Please ask for: Nicola Moore
Email: nicola.moore@arun.gov.uk
Telephone: Ext 37944
Our Ref: BE/115/21/HH
Your Ref:
Date: 15th July 2021

Application for Planning Permission for Works or Extension to a Dwelling

Development: Loft conversion to form new 2nd floor with roof alterations to form gable end.
Location: 19 South Way Bersted PO21 5HB

sheet 2 a of 3

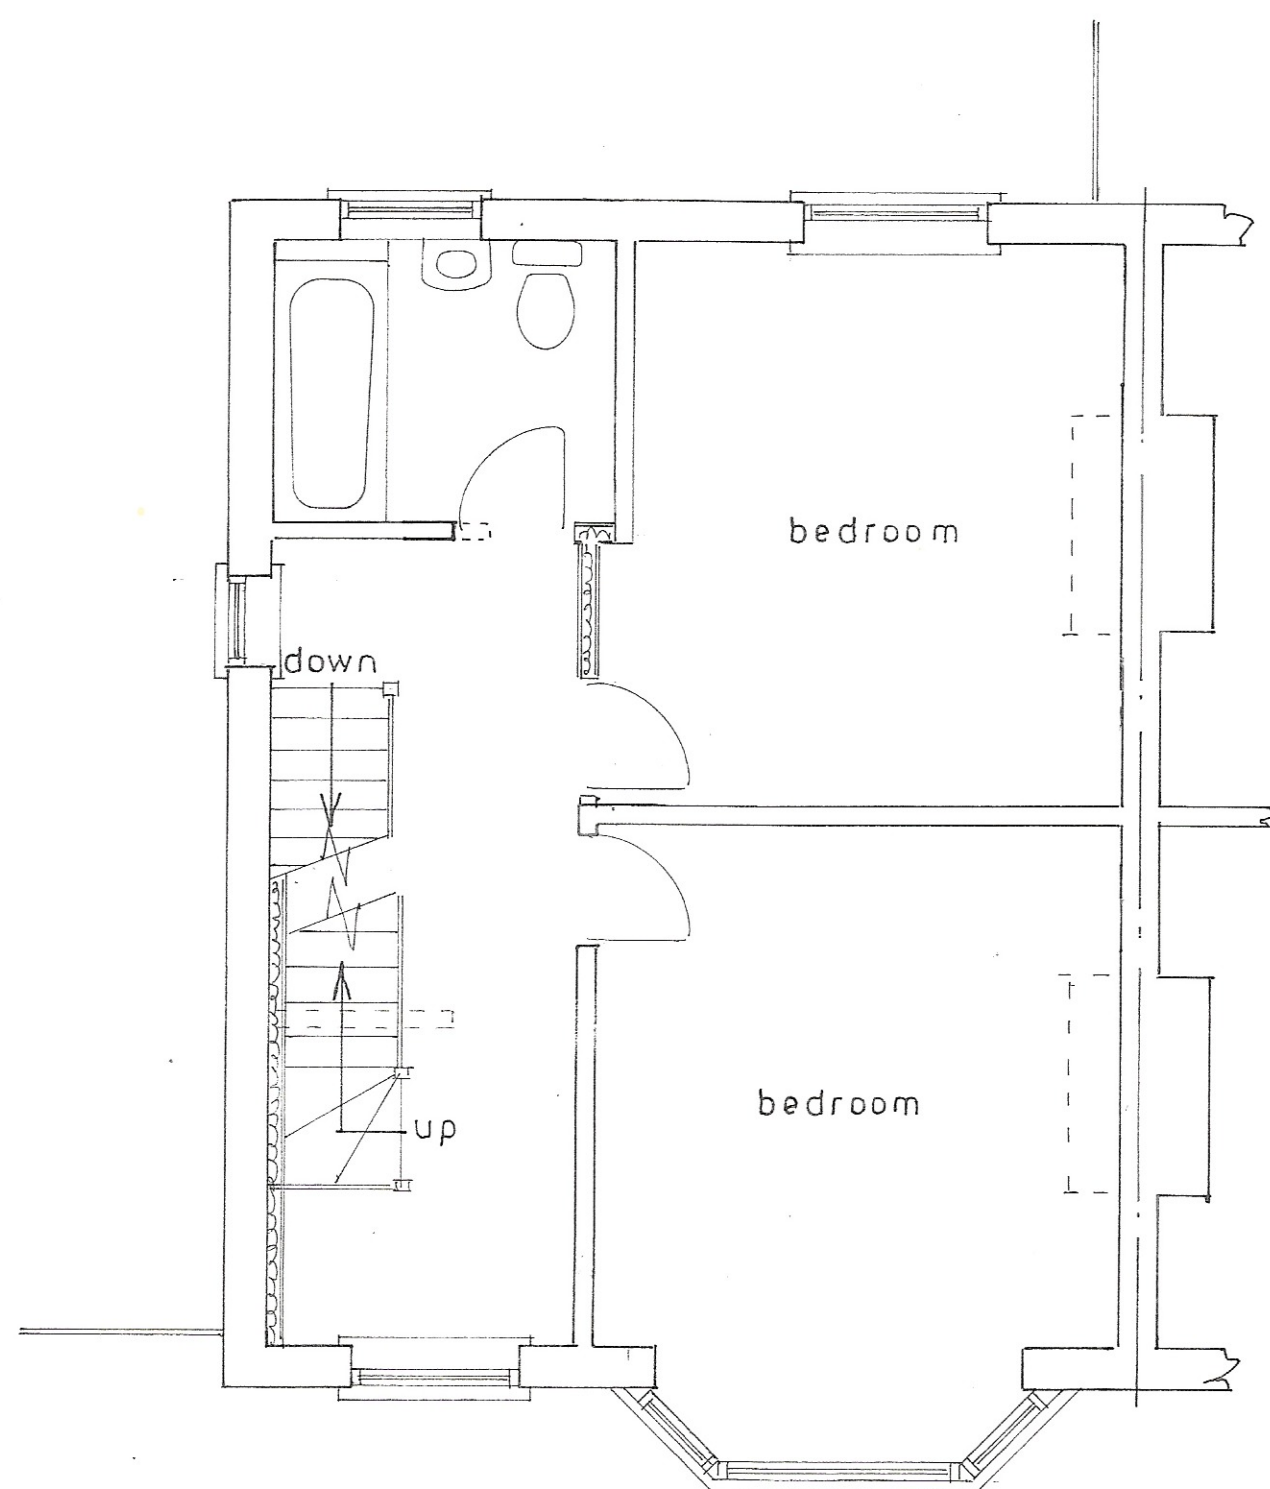
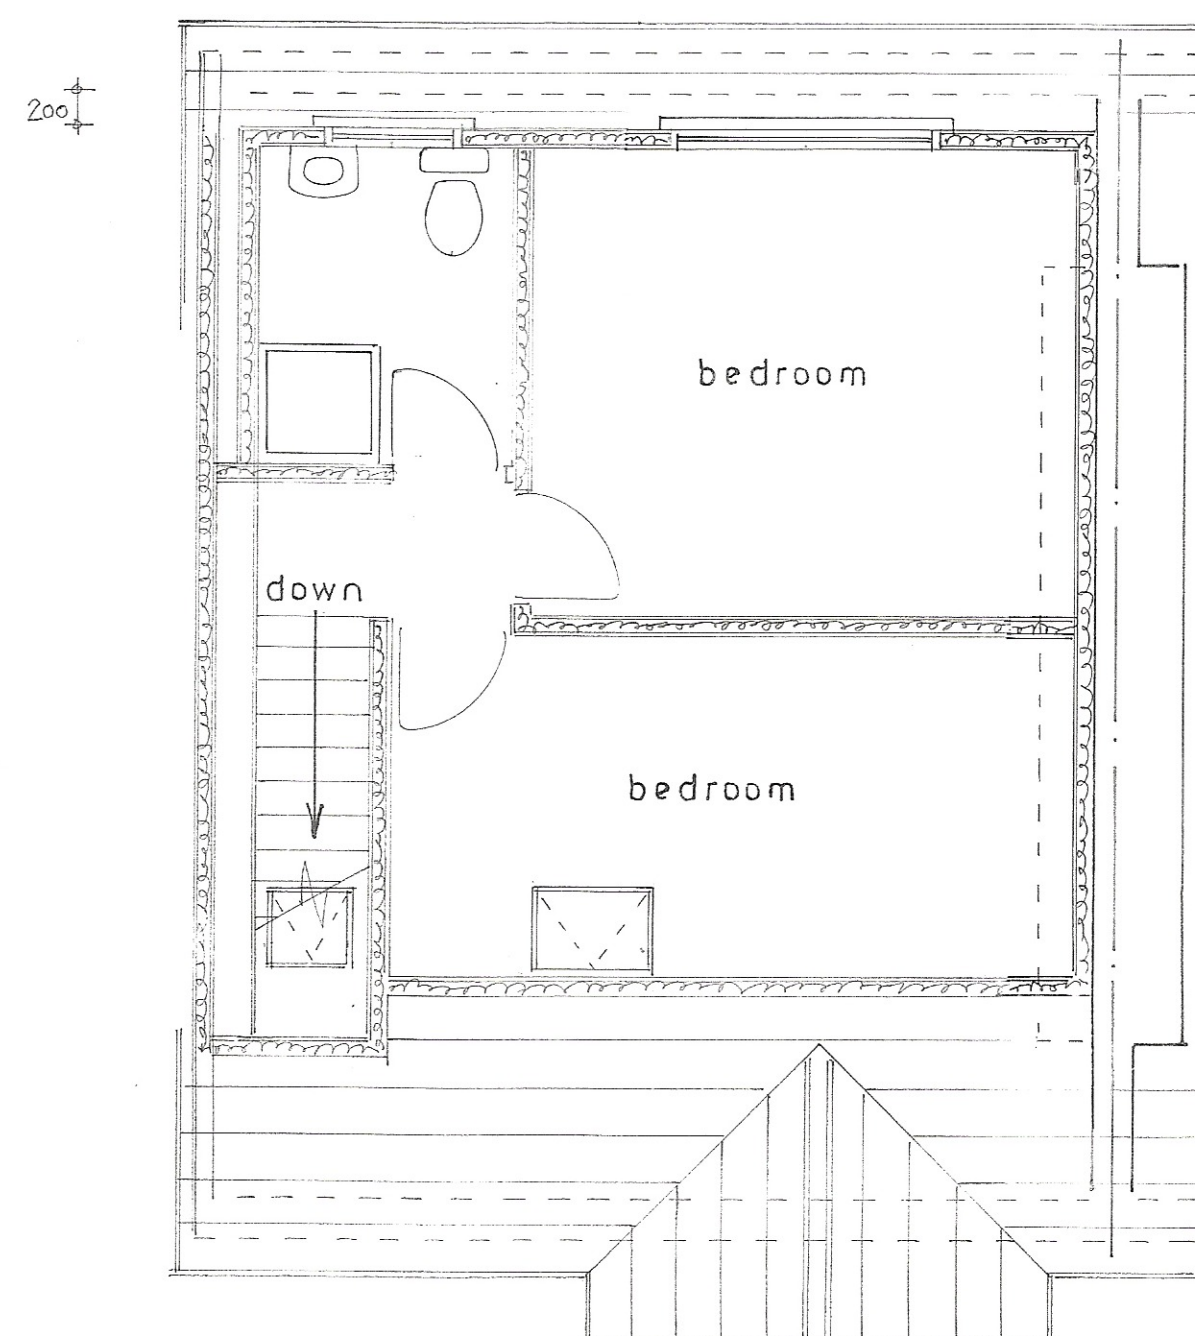
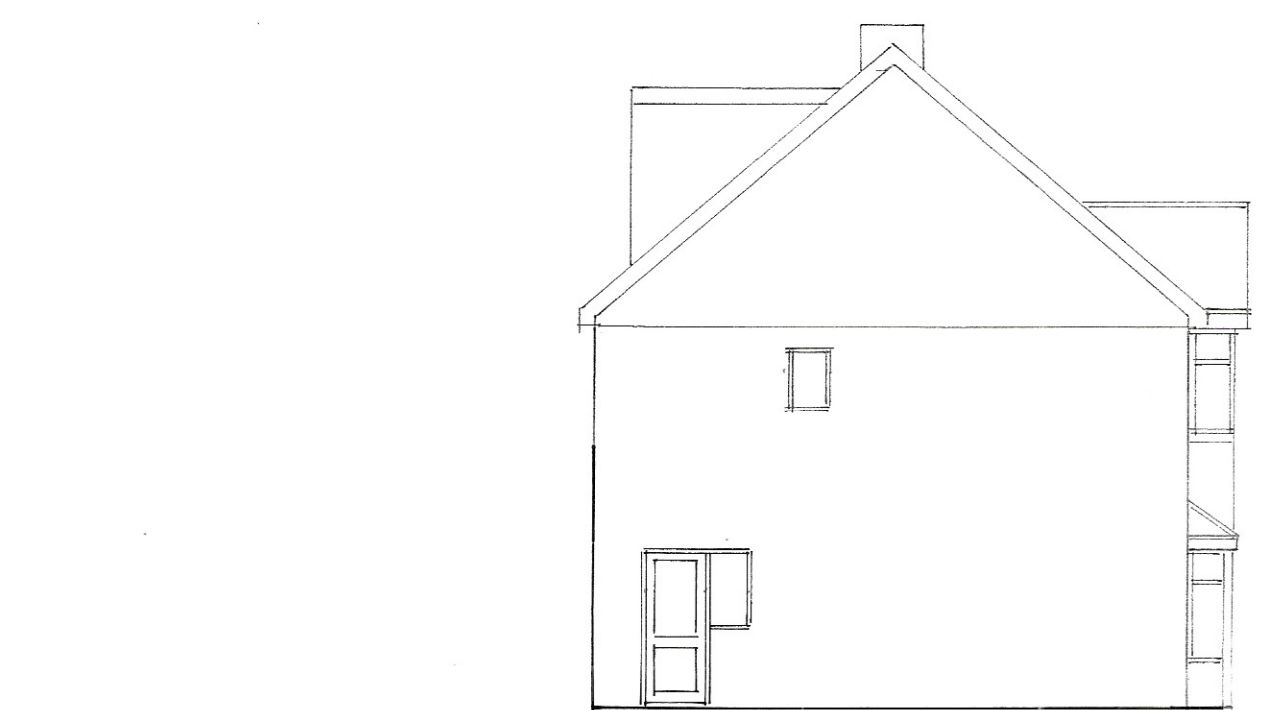
The 2nd floor windows on the Proposed East Elevations measure 1.6m and 1.1m, however on the Proposed 2nd Floor plan they are 1.6m and 0.8m. Please amend accordingly and re submit.
